Our ref: HA/2022/124213/01-L01
Your ref: M/6/22/PL

Date: 27 May 2022

DEMOLITION OF EXISTING BUNGALOW AND ERECTION OF 1 NO 2-STOREY, 4-BEDROOM DETACHED HOUSE WITH 3 NO OFF ROAD CAR PARKING SPACES.

88 ANCTON WAY ELMER MIDDLETON-ON-SEA PO22 6JP

Proposed First Floor Plan

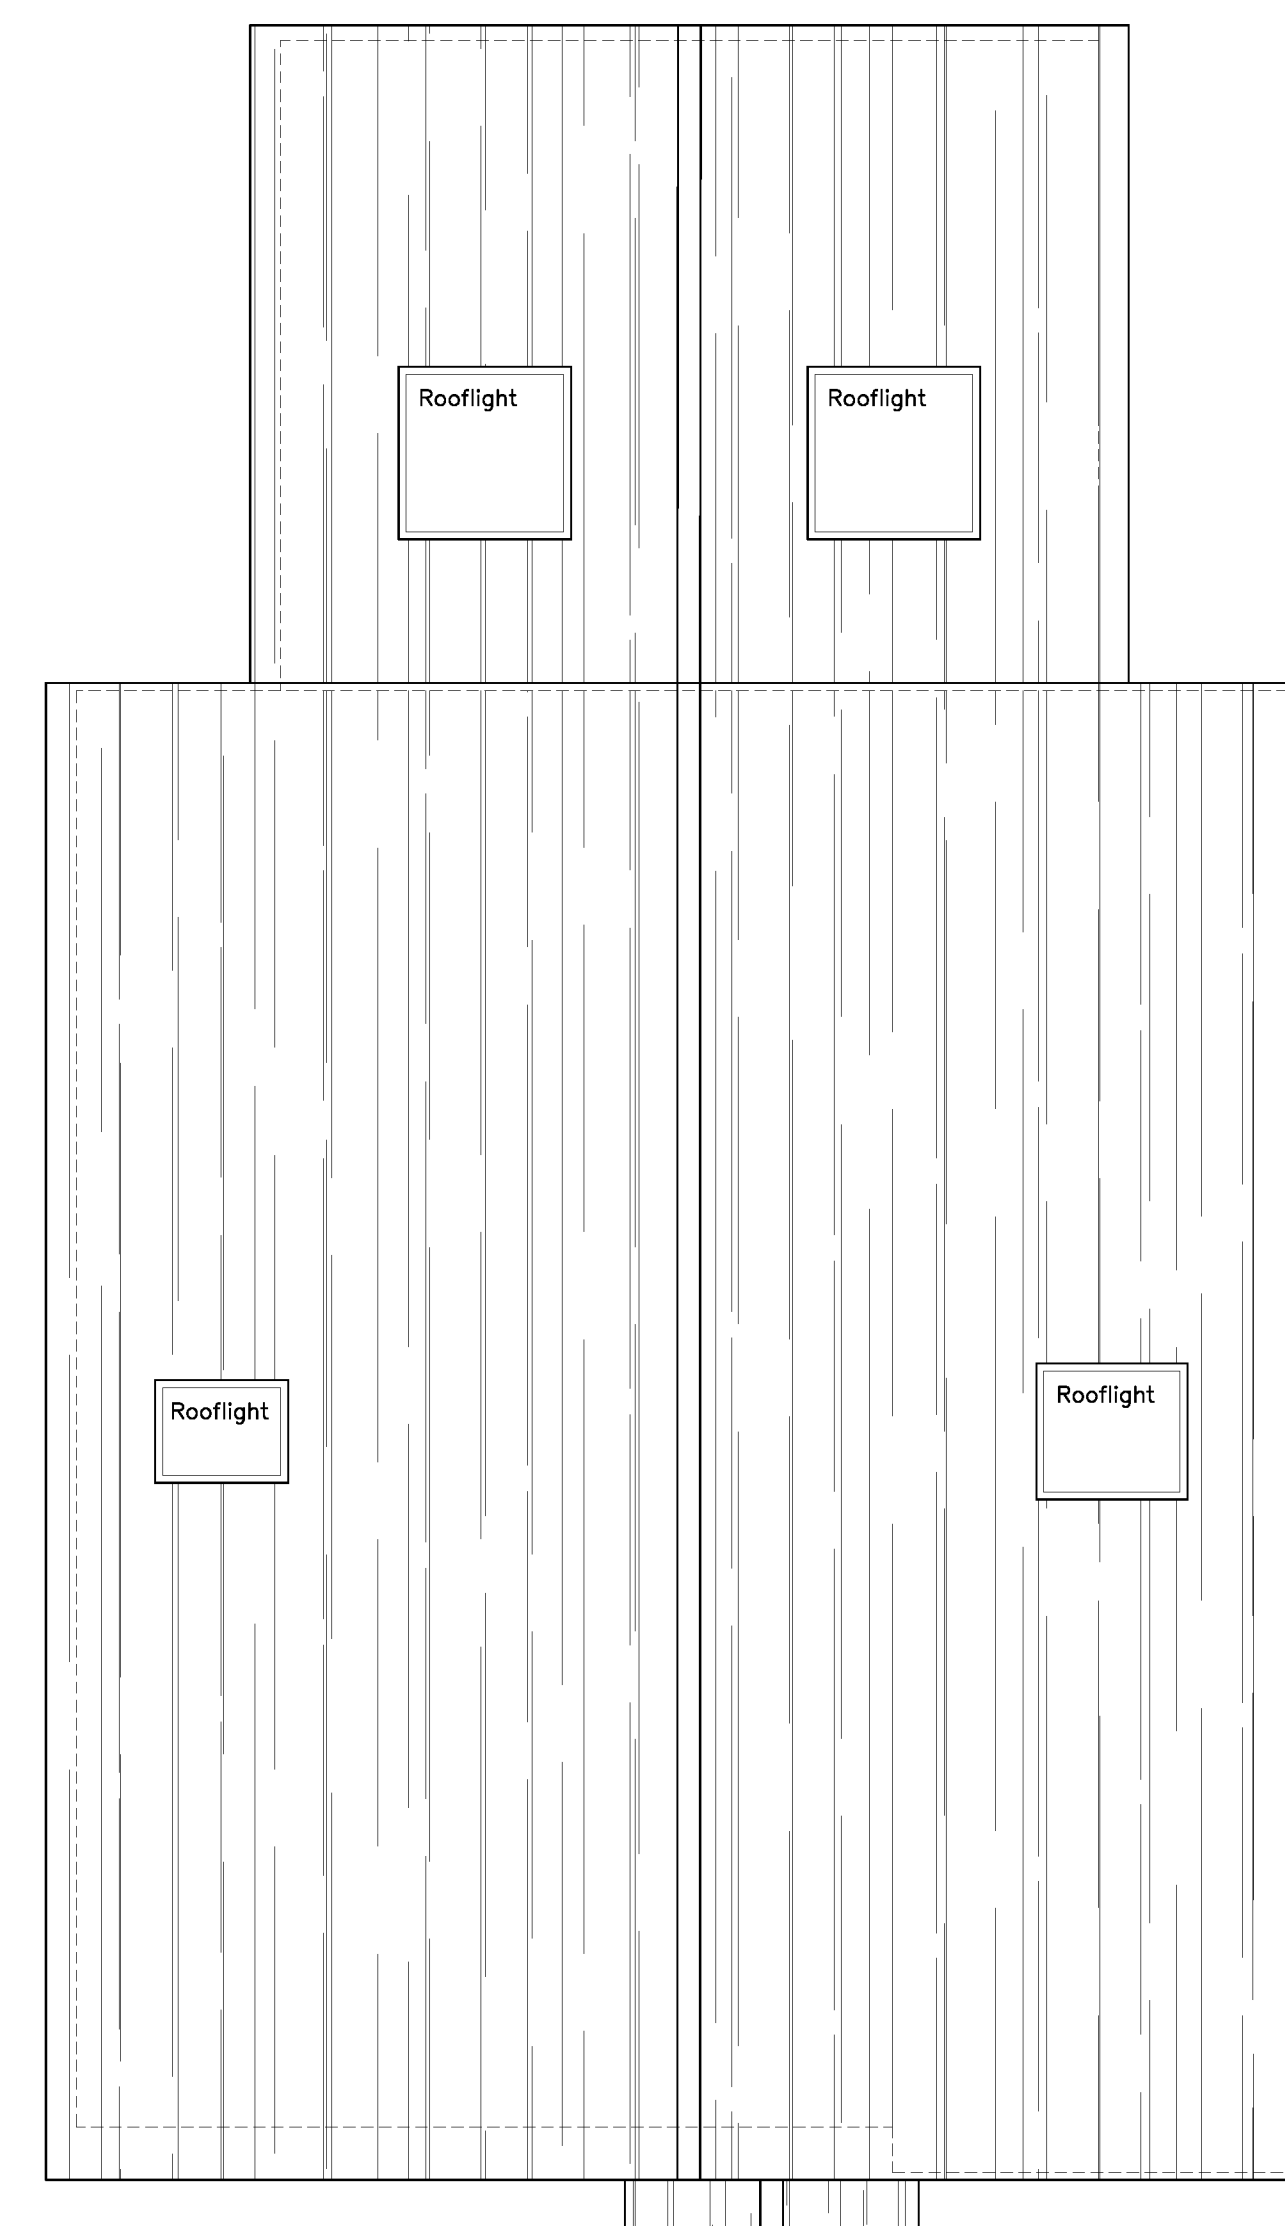
- **All sleeping accommodation will be located on the first floor and above**
